# RTS Response Statement

## Heritage Interpretation

Date: 22 November 2022

Project: TOGA Central

Figure 124 – Heritage Interpretation opportunities..

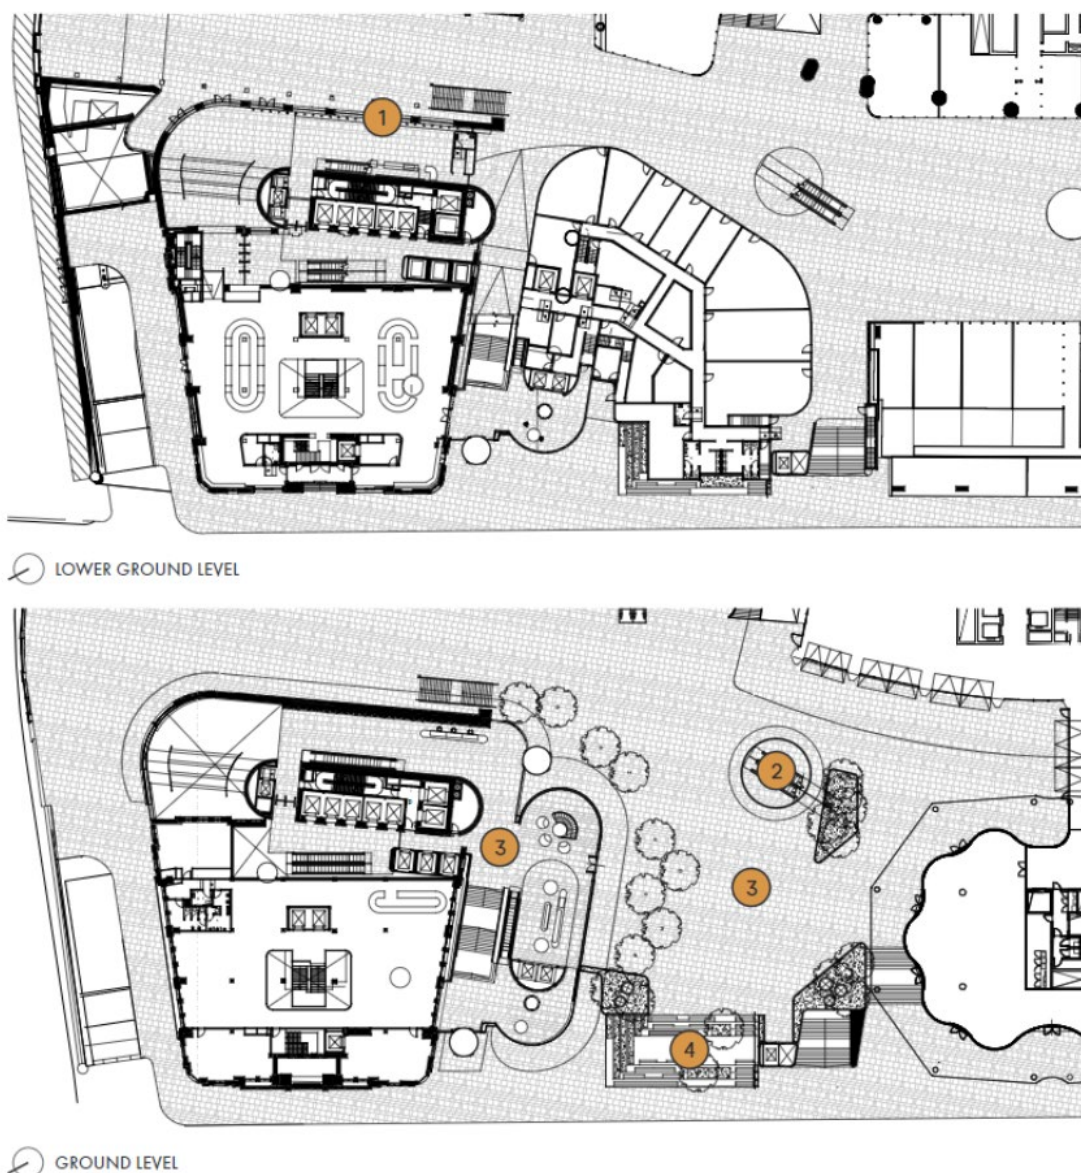
- The interpretation strategies within the HIS should include more pertinent locations relating to the building itself. Interpretation should be located on each facade, within the building on each level and in the more frequented space such as lift lobbies.

- The Heritage Interpretation Strategy has proposed locations for interpretation that maximise their exposure to and impact on visitors, taking into account the circulation patterns throughout the site. FRD will review these locations in collaboration with Bates Smart, Urbis and Arcadia, to be further developed in the Heritage Interpretation Plan.
